Re: Review of the Environmental Assessment for the Redevelopment of Sydney Fish Markets (MP10_0060)

I refer to the Department of Planning's (DoP) request for review and comment on the Environmental Assessment (EA) for the Redevelopment of Sydney Fish received 22 September 2010. The Department of Environment, Climate Change and Water ("DECCW") have reviewed the EA.

Figure 1 Schematic of a Tri-generation system

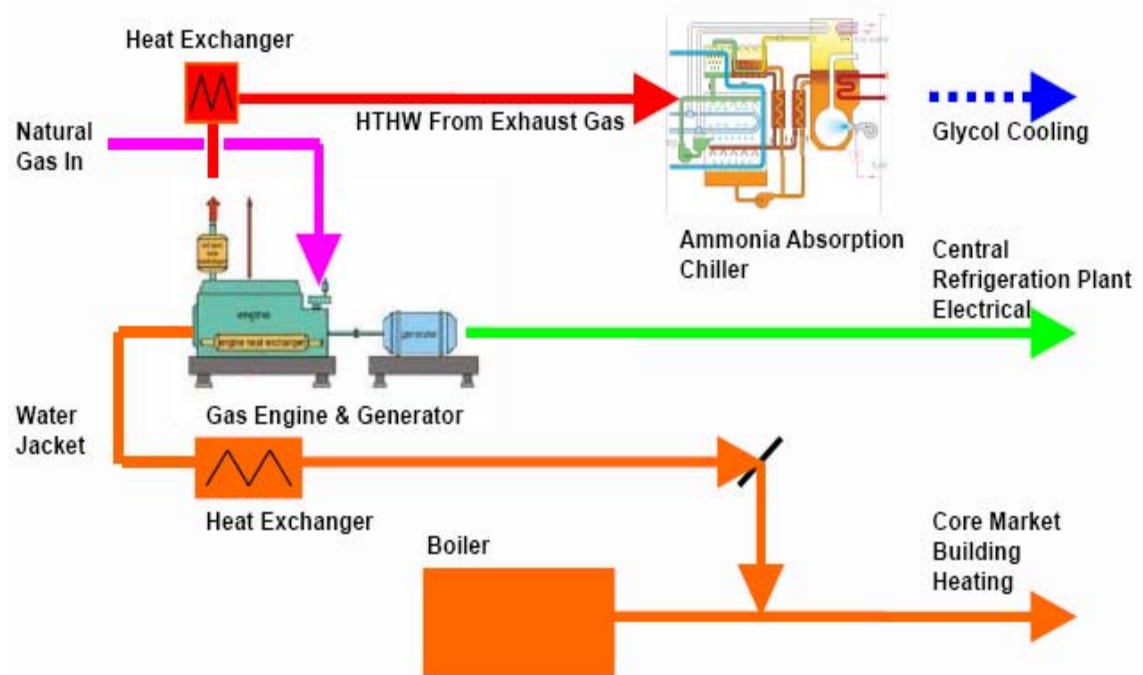
The proponent should also be notified if during further stages of the development the implementation of a co- or tri-generation plant is considered, that an Environmental Protection Licence may be required under the provisions of the *Protection of the Environment Operations Act 1997*.

A co- or tri-generation plant is likely to require a licence if it generates electricity through the use of an internal combustion engine that has the capacity to burn more than 3 megajoules of fuel per second. Reference should be made to Schedule 1 of the *Protection of the Environment Operations Act* for full details of the licensing thresholds for electricity generation (available at: <http://www.legislation.nsw.gov.au/maintop/view/inforce/act+156+1997+cd+0+N>).
